From: Hughes, James D. <jhughes@cabq.gov>
Sent: Friday, May 19, 2023 4:22 PM
To: Madelyn Schauer <madelyn@inspectionsplus.com>
Cc: coronado113@qwestoffice.net <coronado113@qwestoffice.net>; Dave Doyle <dave@nminnovate.com>; jamiegalles@galles.com <jamiegalles@galles.com>
Subject: 23.05.19 ESC Plan comments for Galles Chevrolet Parking Lot at 2001 Candelaria Rd. NE & Motel 1 Demo - H15E007 - NMR1005MK

Subject: 23.04.17 ESC Plan comments for Galles Chevrolet Parking Lot at 2001 Candelaria Rd. NE & Motel 1 Demo - H15E007 - NMR

INTERIM GRADING & DRAINAGE PLAN

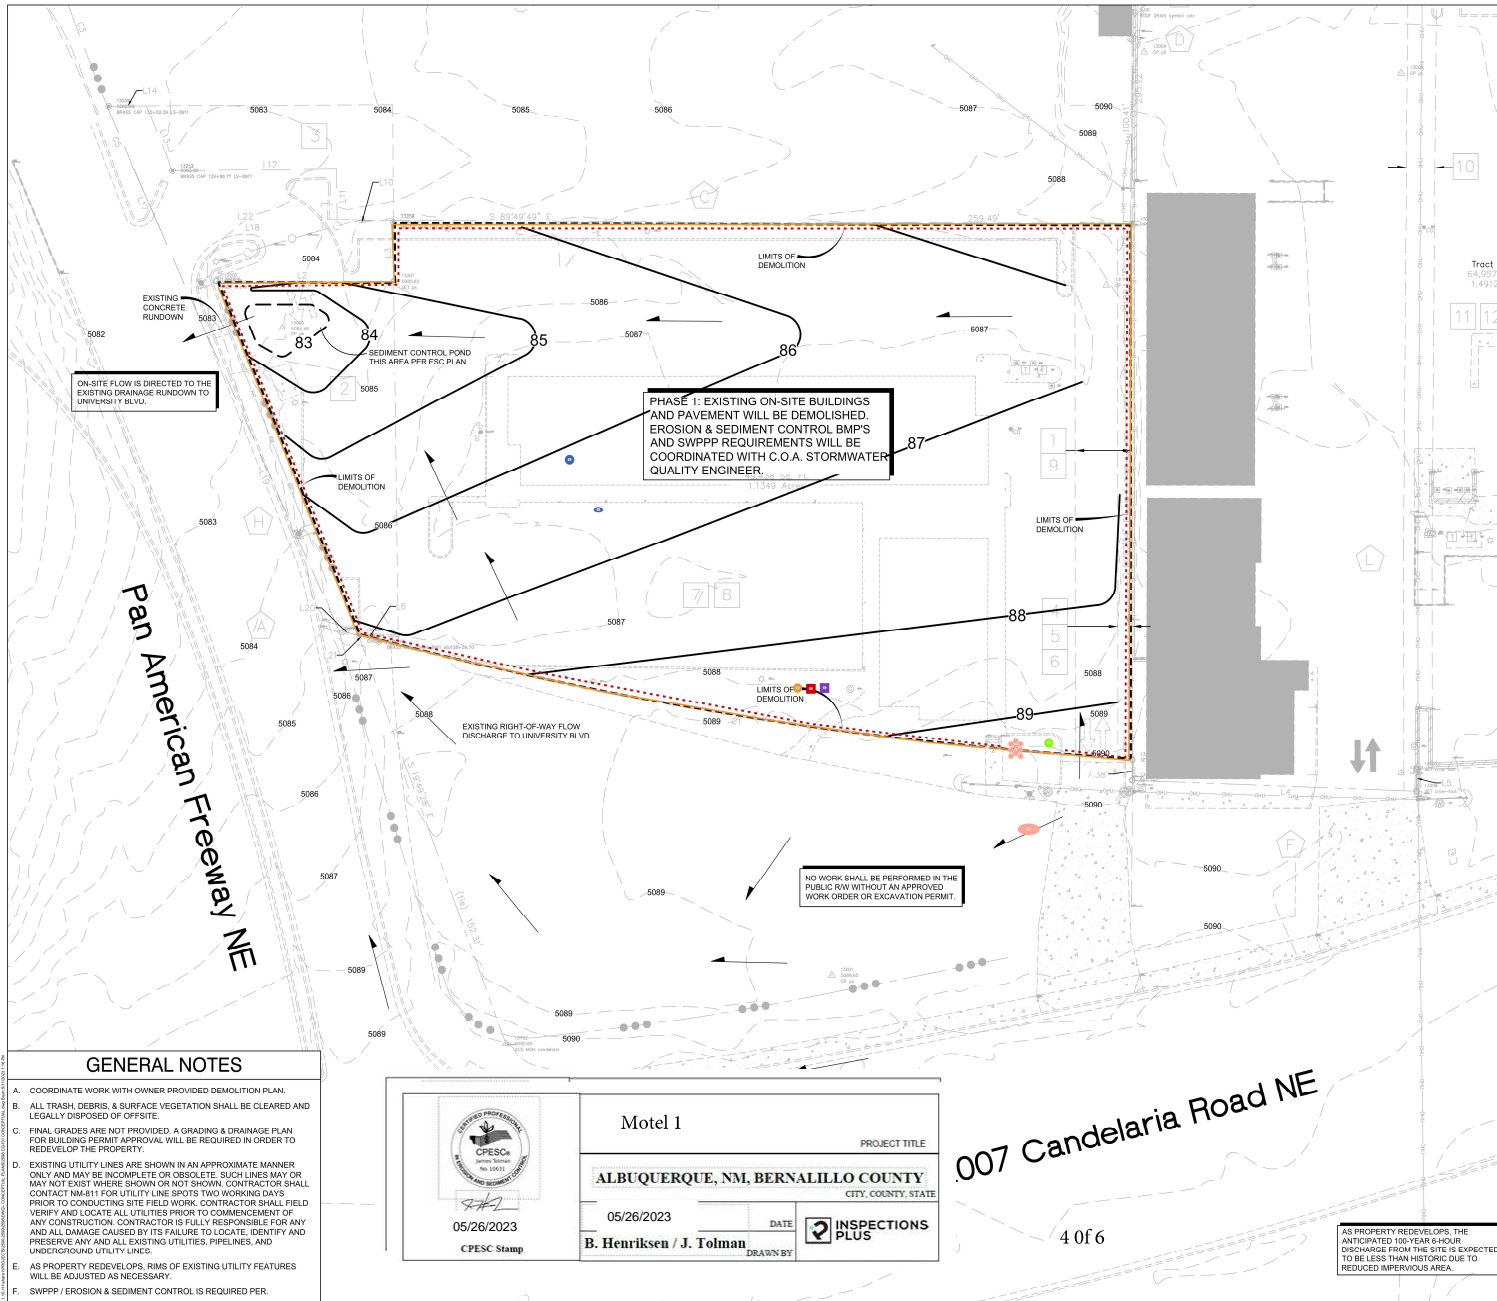
It seems like the plan is to get rid of the building and parking lot and to leave bare dirt until sometime in the future. There isn't any acknowledgement of the permit requirements that will apply to the dirt lot. If the lot is to remain inactive for 14 days or more, you must begin applying seed and hydromulch within 14 days, and you must complete the seed and mulch within in 14 days from the day you start per CGP 2.2.14. Then you must continue permit coverage, self-inspections, SWPPP and BMP maintenance until the City determines that the Final Stabilization Criteria CGP2.2.14.c has been satisfied.

Untitled Map

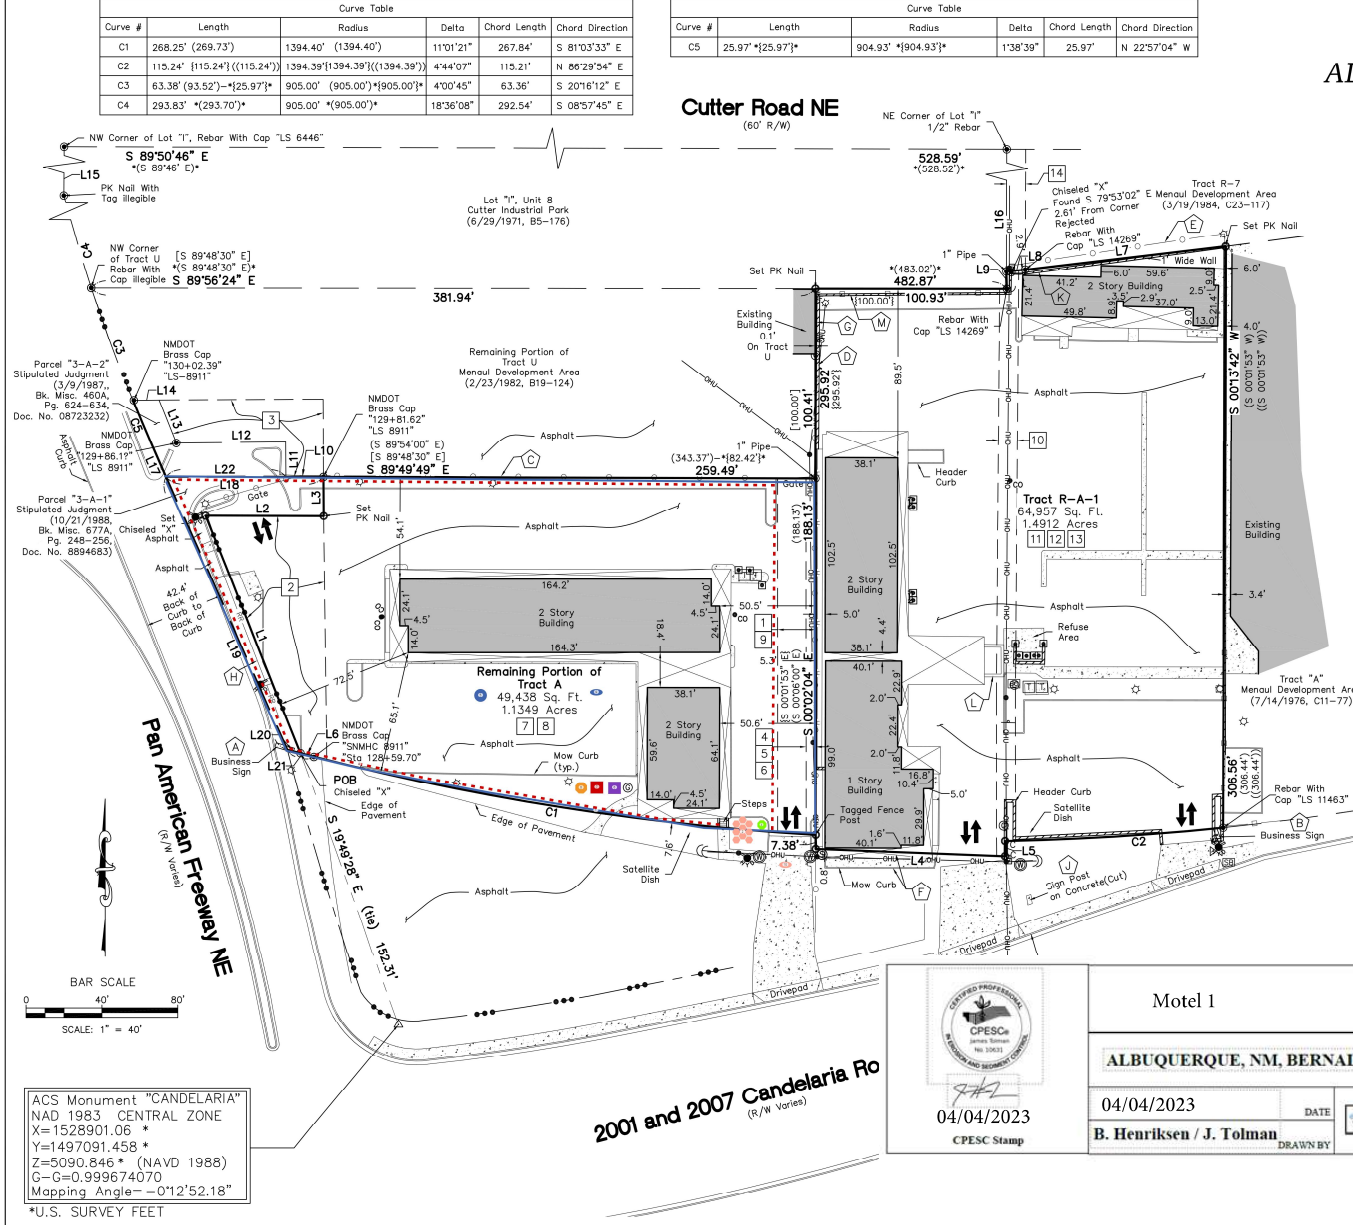
The demolition of the Motel 1 building and parking lot requires an NOI and SWPPP. See attached DEMO exhibit. The paved area south of Motel 1 is in the public ROW and is labeled "fenced but will not be disturbed". Apparently Galles Chevrolet is leasing the Motel 1 property, but the plans for this site are vague and nearly nonexistent. If so, Galles will need an NOI and I will need to verify the lease.
